CITY OF ALBUQUERQUE

June 17, 2016

Re: Bogan Brothers Painting
3435 Vassar Dr., NE
Traffic Circulation Layout
Engineer's/Architect's Stamp **6-6-16** (G16-D150)

TCL

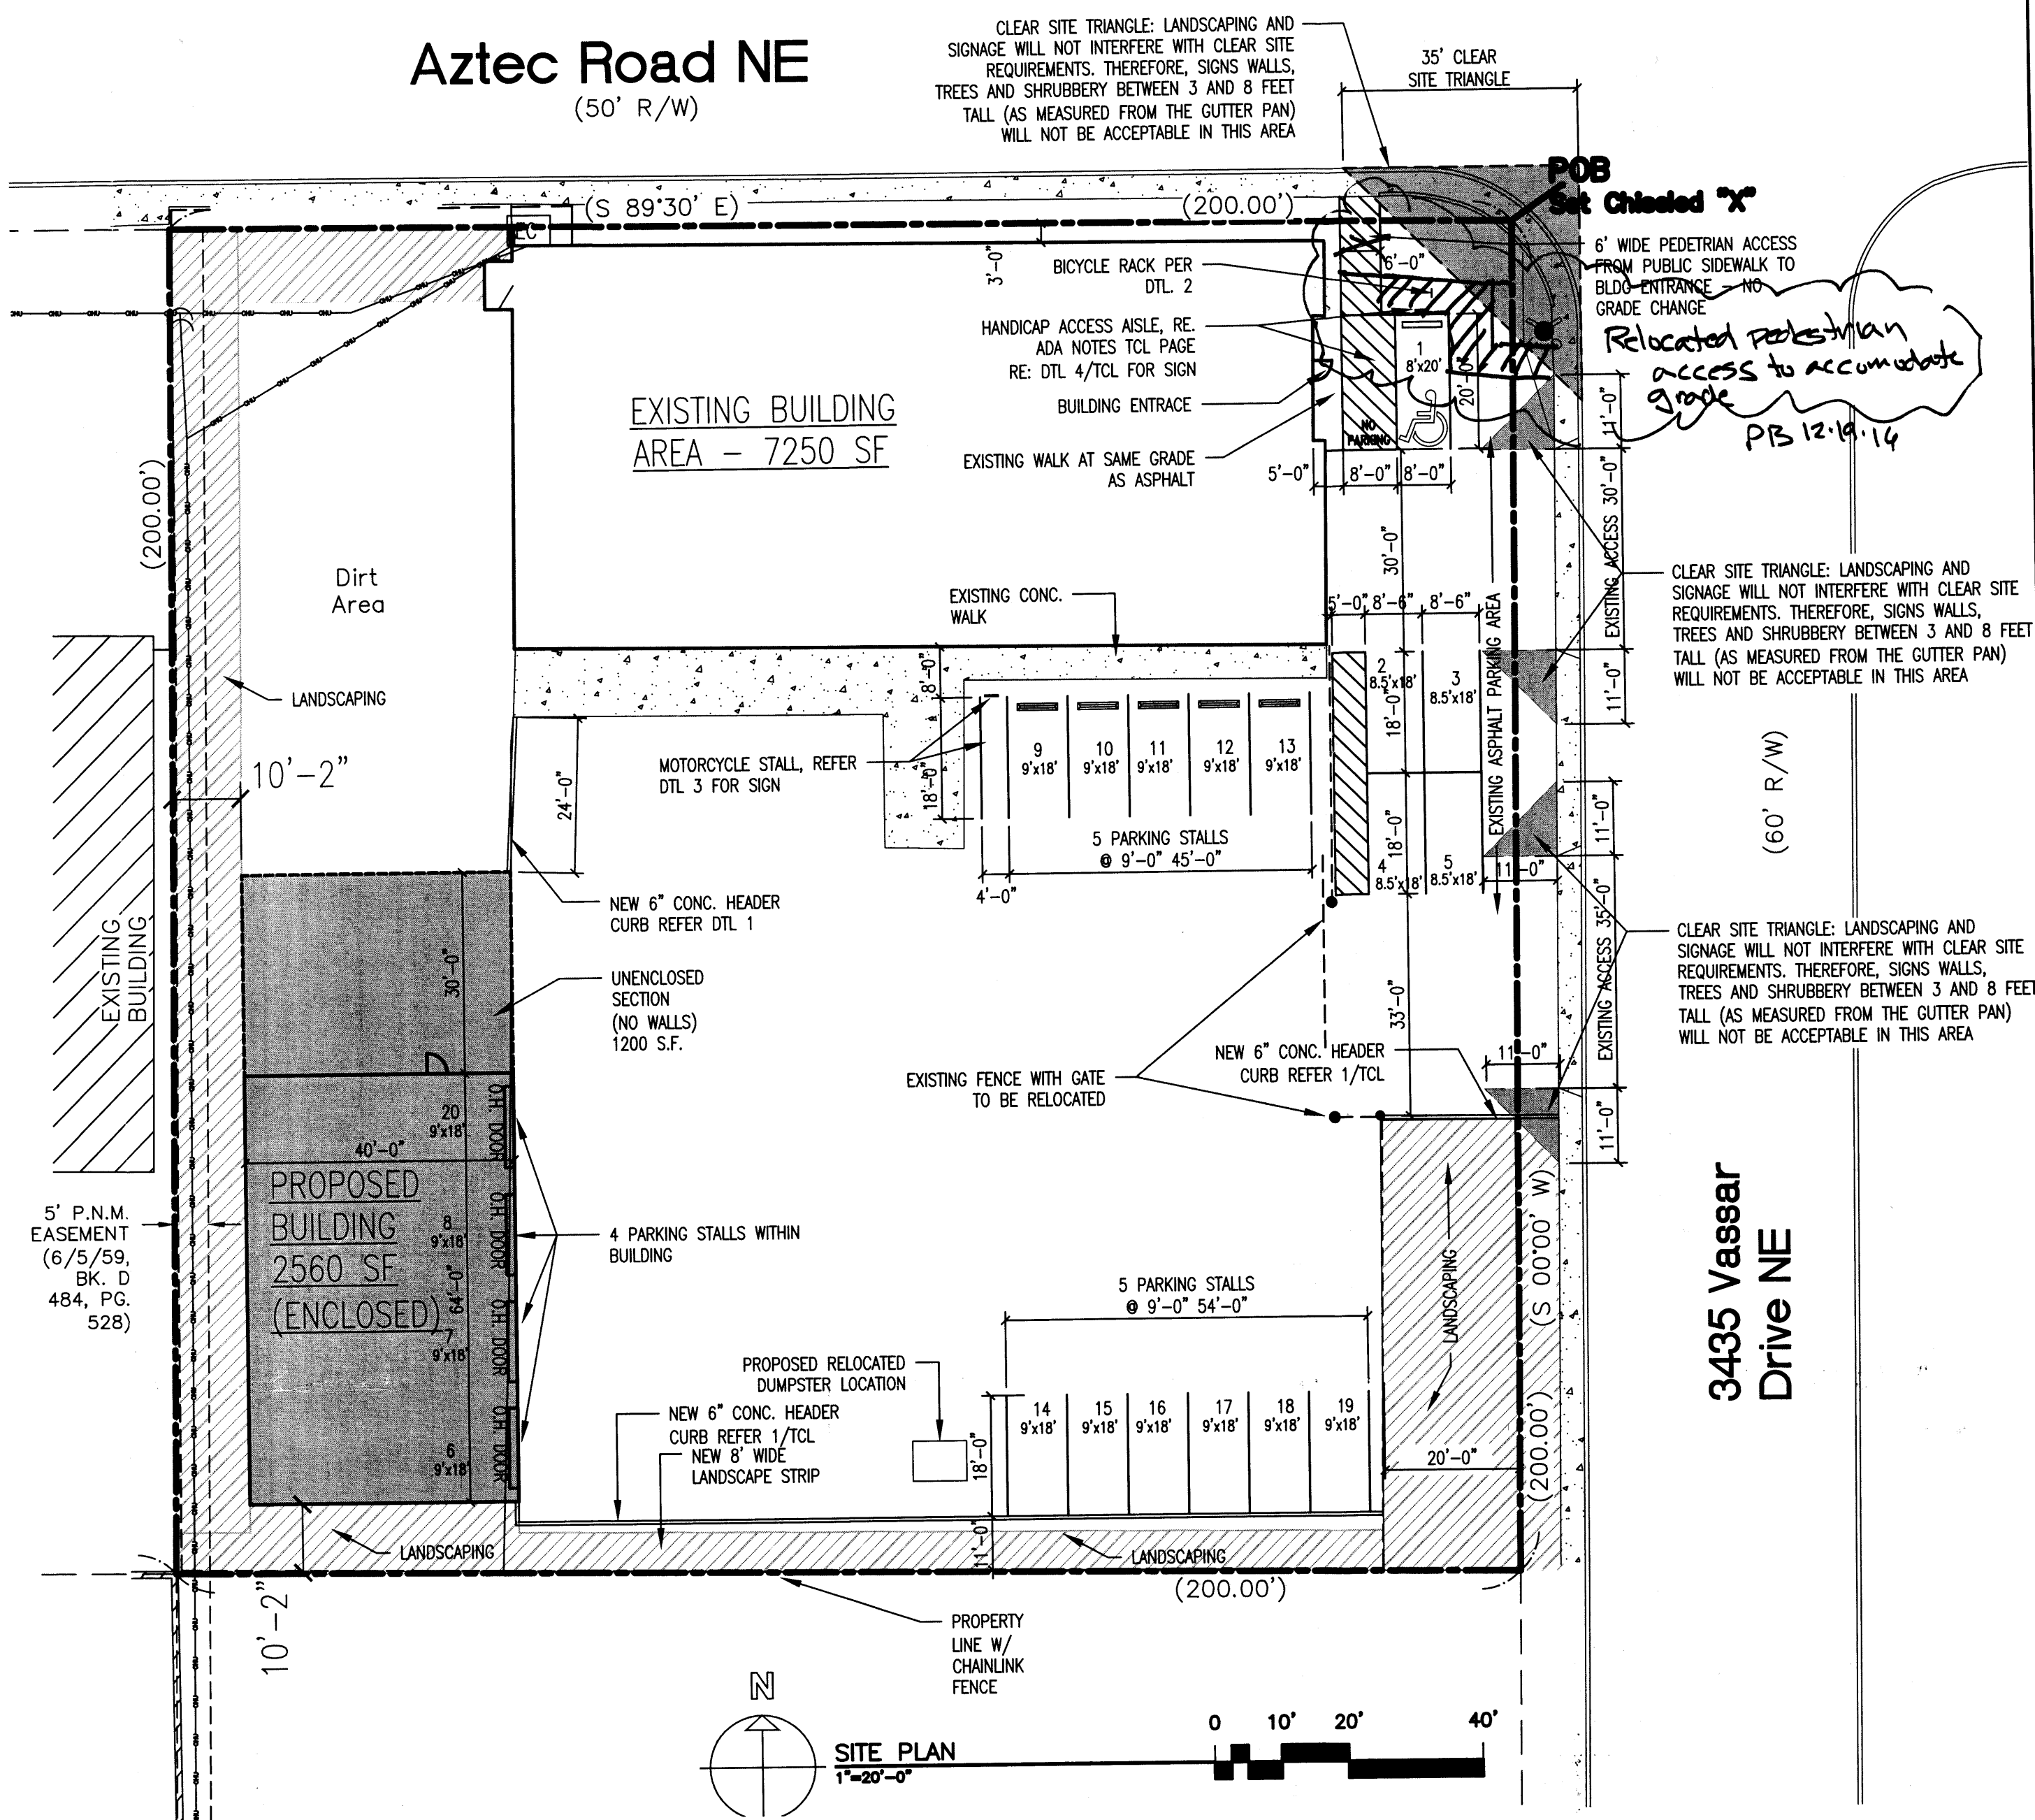
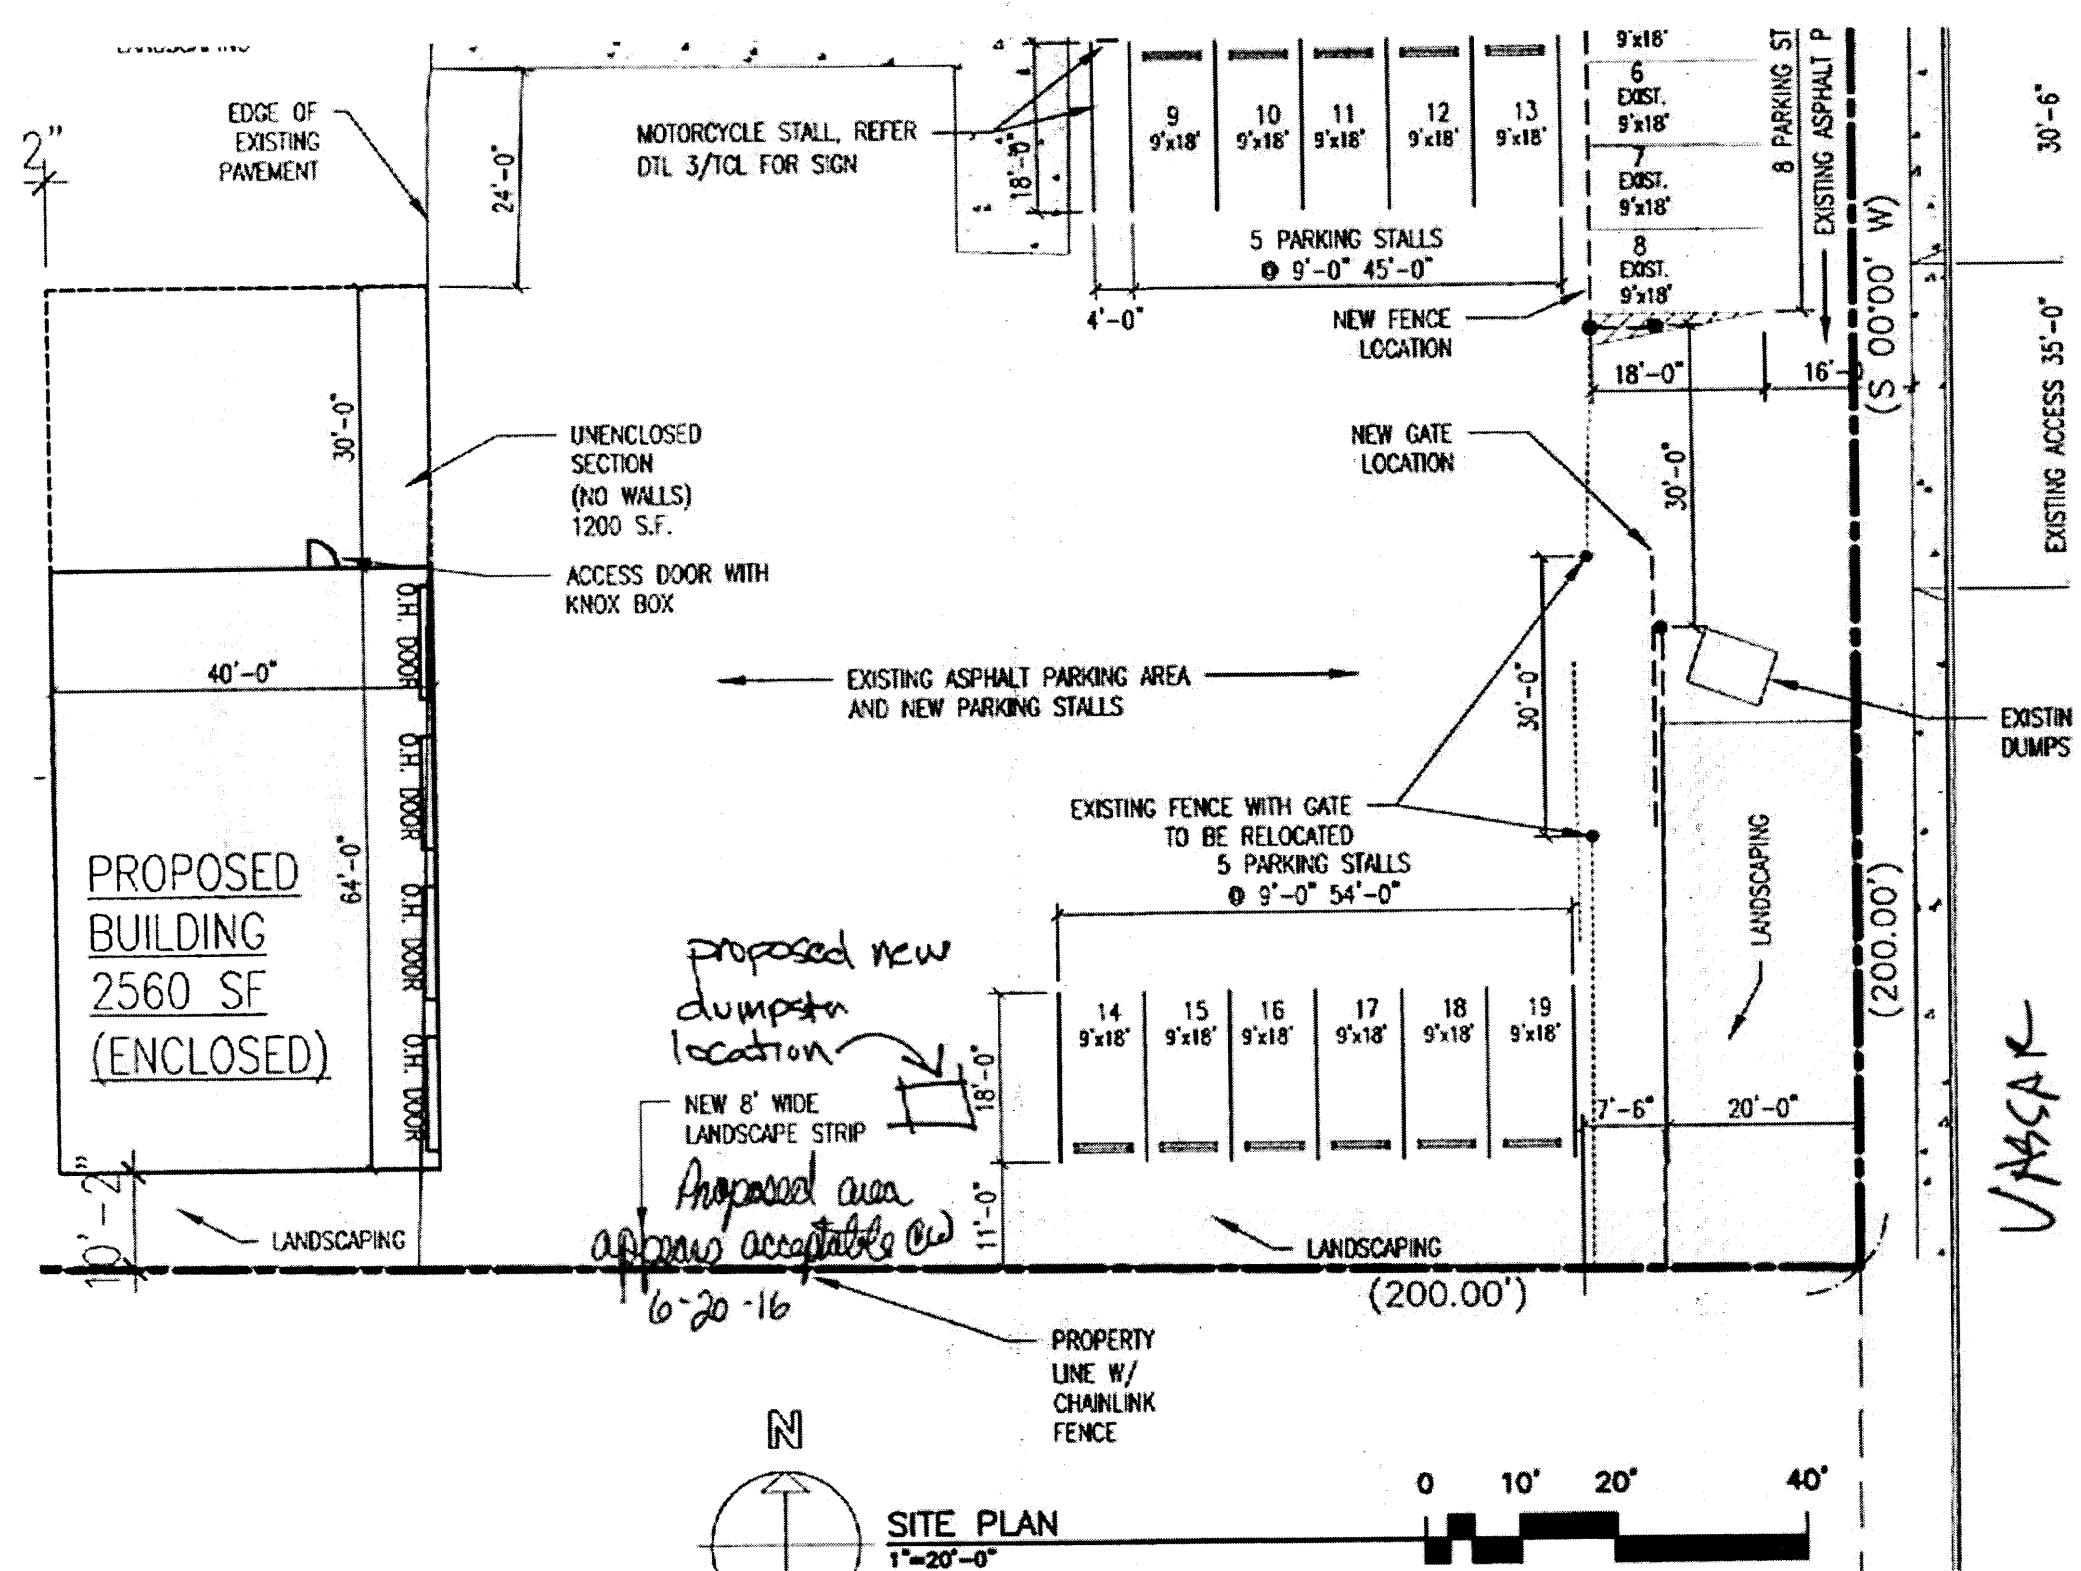
1. Please dimension all sidewalks, drive pads, ADA ramps and anything that influences the parking and circulation on the site.
2. Per DPM, a 6 ft. wide ADA accessible pedestrian pathway is required from the public sidewalk to the building entrances. Please clearly show this pathway and provide details.

3. Per DPM, a 6 ft. wide ADA accessible pedestrian pathway is required from the HC parking stall access aisles to the building entrances. Please clearly show this pathway and provide details. Please dimension the access isle.

4. Provide a min 6" or max 8" high concrete barrier curb or other acceptable barrier between landscaping and parking areas and/or drive aisles. Please call out detail and location of barrier curb.

5. Service vehicle and/or refuse vehicle maneuvering must be contained on-site; provide a copy of refuse approval.
6. Please provide a sight distance exhibit (see the *Development Process Manual, Chapter 23, Section 3*). Please add this detail for entrances/exits on Vassar Dr.

7. Please add the following note to the clear sight triangle: "Landscaping and signage will not interfere with clear sight requirements. Therefore, signs, walls, trees, and shrubbery between 3 and 8 feet tall (as measured from the gutter pan) will not be acceptable in this area."
8. Unused curb cuts must be replaced with sidewalk and curb & gutter. A build note must be provided referring to the appropriate City Standard drawing.
9. All broken or cracked sidewalk must be replaced with sidewalk and curb & gutter. A build note must be provided referring to the appropriate City Standard drawing.
10. Please include two copies of the traffic circulation layout at the next submittal.
